From: Caroline Ford
Sent: 21 November 2019 10:08
To: DC Support
Subject: FW: 19/01036/HYBRID - Bicester Eco Town Exemplar Site Phase 2, Charlotte Avenue, Bicester

RE: Development of a new Local Centre comprising Retail, Commercial and Community floorspace (flexible Use Class A1/A2/A3/B1/D1), and 38 residential units (use class C3) with associated access, servicing, landscaping and parking

SCALE: <b>1:250</b>	DRAWING SHEET SIZE: <b>A1</b>	
JOB CODE: <b>LELC2</b>	DRAWING NUMBER: <b>ADP-00-GF-DR-A- L-1000</b>	REVISION: <b>S2 P2</b>

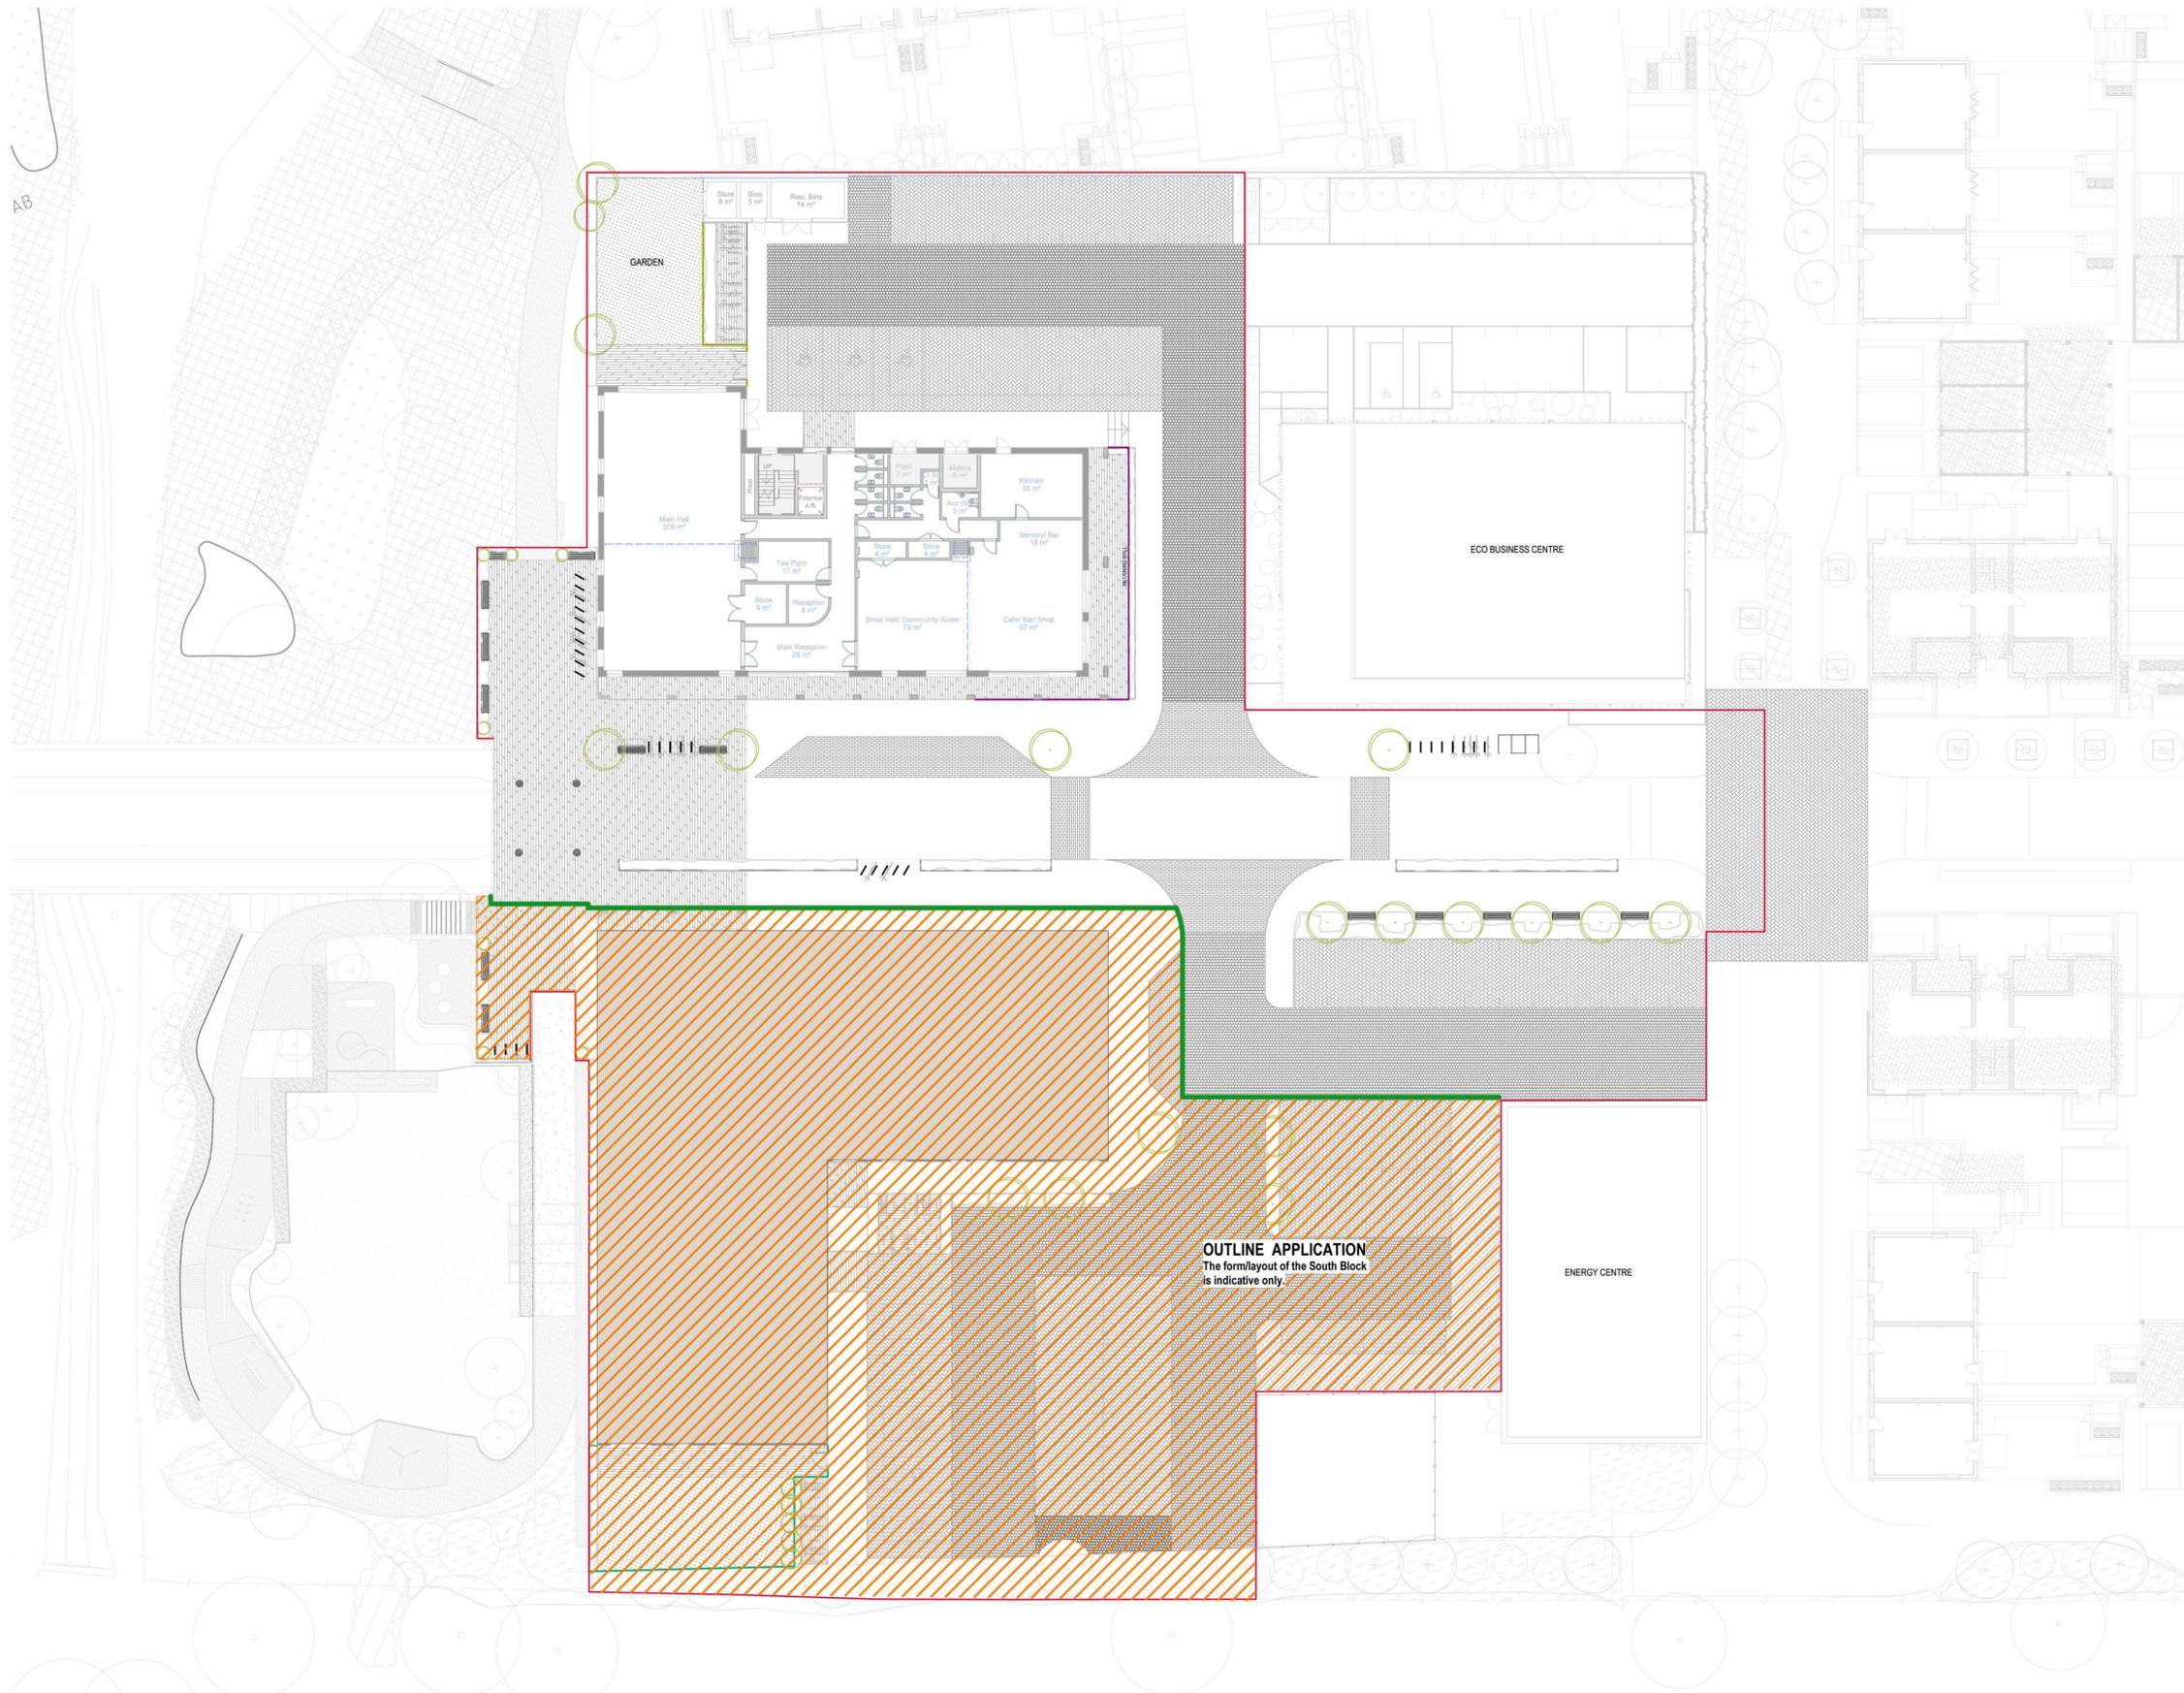
In consideration of Landscape GA plan ADP-00-GF-DR-A-L-100 S2 P2

There is currently very little scope for structure planting within the large expanse of hard area/car parking to the north side of the building without any relief on terms of amenity and environmental benefit (shading and cooling) amelioration. I would encourage the use of feature trees within the car park and formal hedging on the northern boundary

The community garden requires additional landscape design.

I am pleased to see a good proportion of street tree planting, especially the line of trees interplanted between seats north of the Energy Centre. However, I am concerned about bird droppings onto seats and recommend fastigiate trees to reduce this problem (to prevent overhanging branches). Also the seats to have armrests to prevent skaters from using them (although this is also dependant on the smoothness of the surface paving).

The original landscape drawing ADP-00-GF-DR-A-L-1000 indicated an appropriate number and location of proposed trees. The revised landscape scheme must adhere to this requirement, where possible.
